Subject: Rezoning Petition Review

Rezoning Petition #: 22-018

Location of Property: Approximately 72.20 acres located south of Johnston Oehler Rd, east of Prosperity Church Rd and west of Mallard Creek Rd.

JOB NO.
50424
SHEET NO.
RZ-1.0

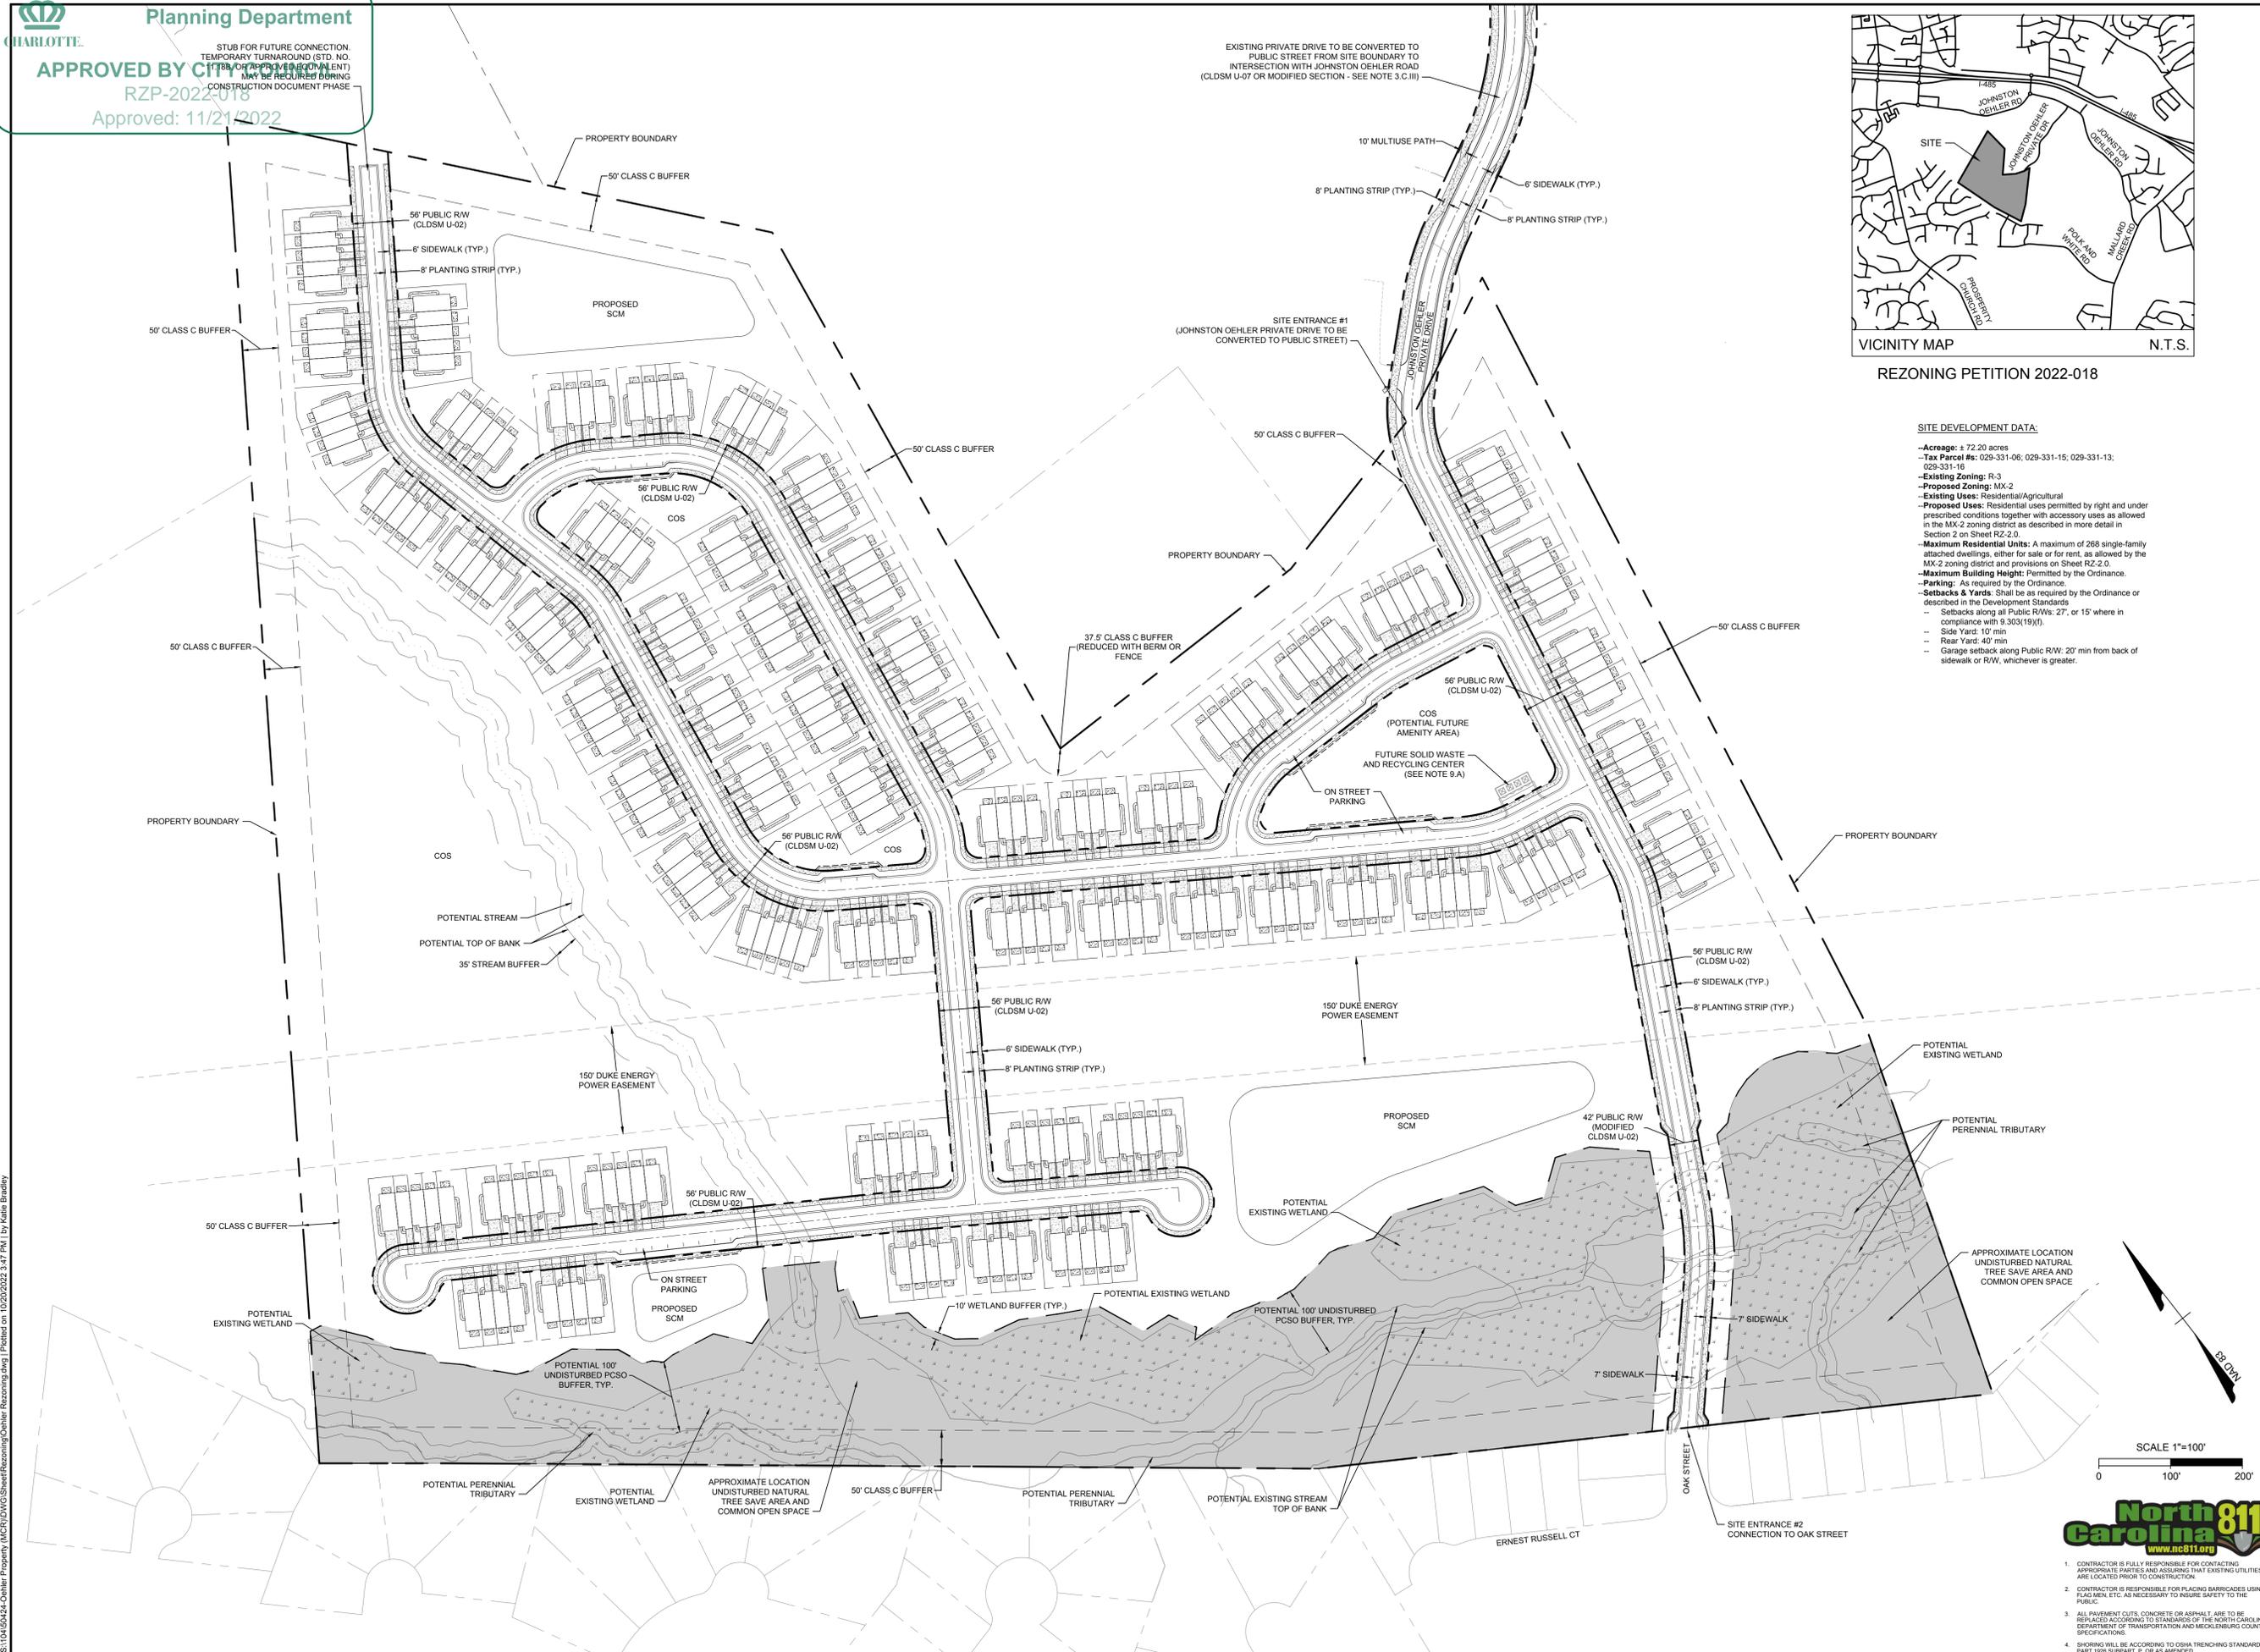
Concerning Storm Water: City of Charlotte GIS data indicates a 100-ft Undisturbed PCSO buffer across the site. Please show and label *Potential 100-ft Undisturbed PCSO Buffer* on the site plan. Any increase of impervious area within such buffers may not be allowed and is not approved with the rezoning process. Stream Delineation Reports are subject to review and approval by Charlotte Storm Water Services. Please include the following note under Environmental Features: *“Development within any SWIM/PCSO Buffer shall be coordinated with and subject to approval by Charlotte-Mecklenburg Storm Water Services and mitigated if required by City ordinance. Petitioner acknowledges intermittent/perennial stream delineation reports are subject to review and approval upon submission of development plans for permitting and are not approved with rezoning decisions.”*
